Martin Nugent  
01254 828060  
D3/12/0356

Drafted 22 June 2012

**Planning Applications, Ribble Valley District  
3/12/0356 Moorcock Inn, Slaidburn Road, Waddington**

Proposed Site Plan 1:200

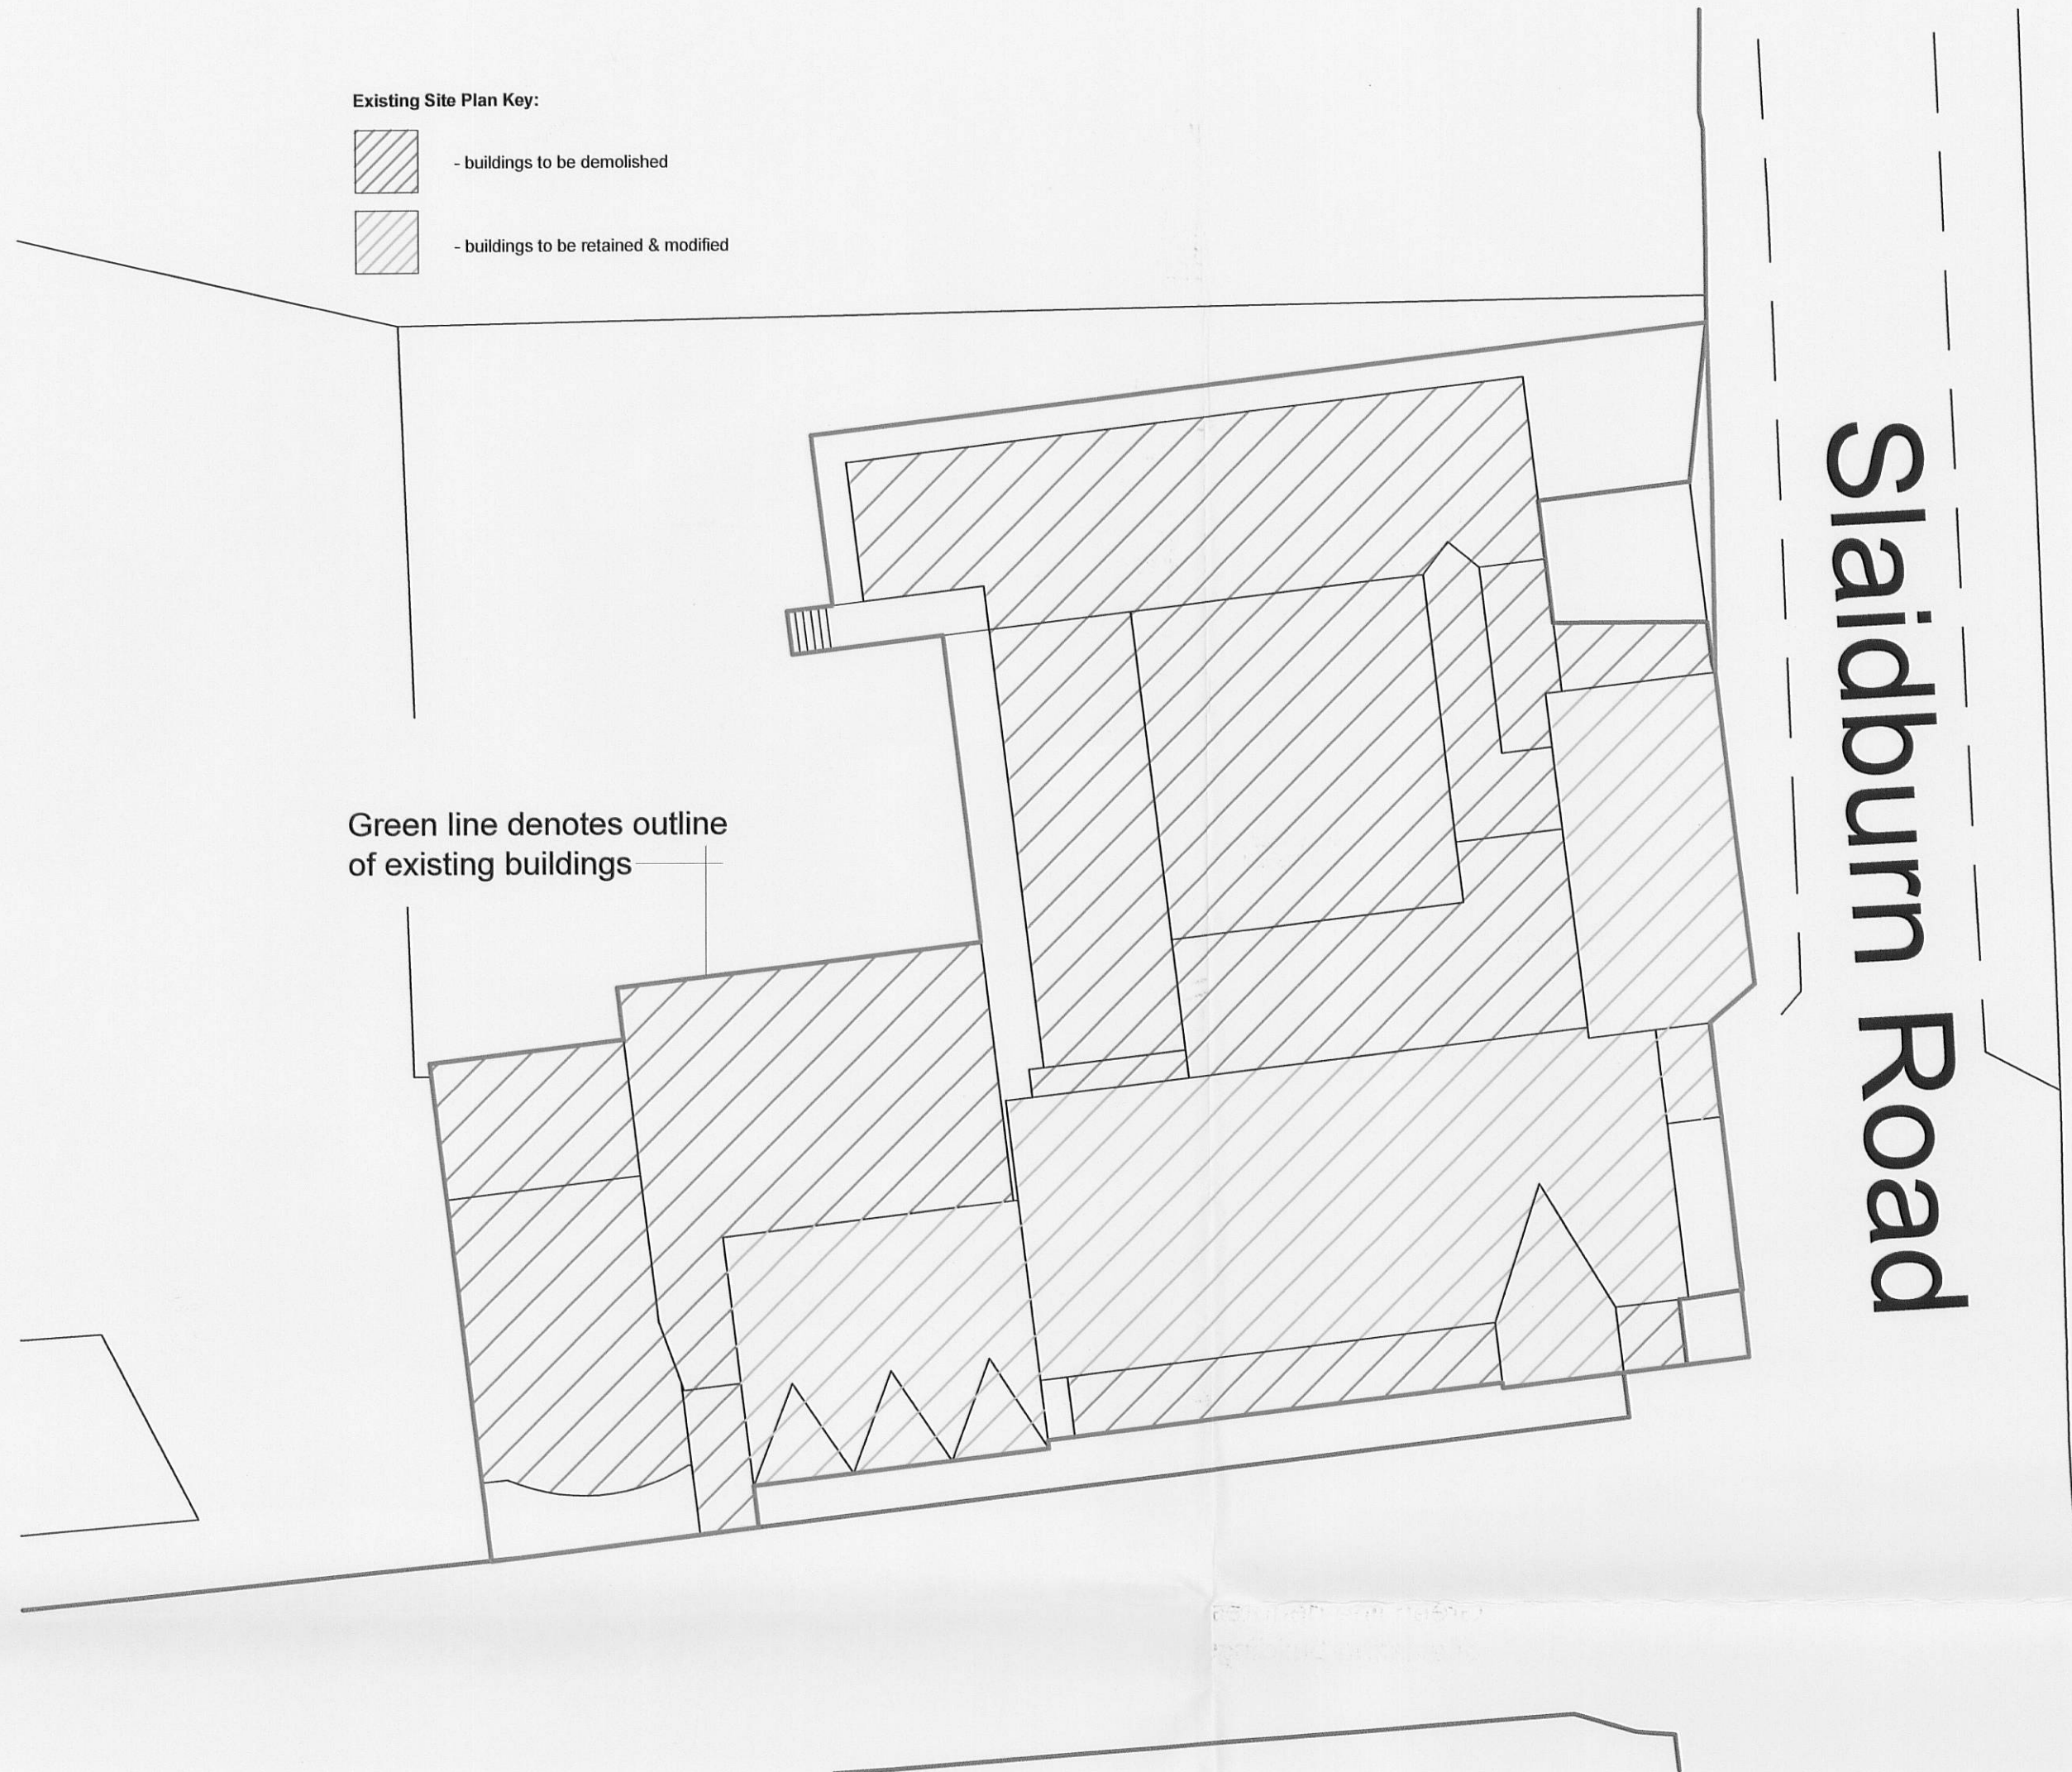
However, I would recommend the addition of a section of footway or similar frontage treatment to provide an element of separation for residents from passing traffic on the access road.
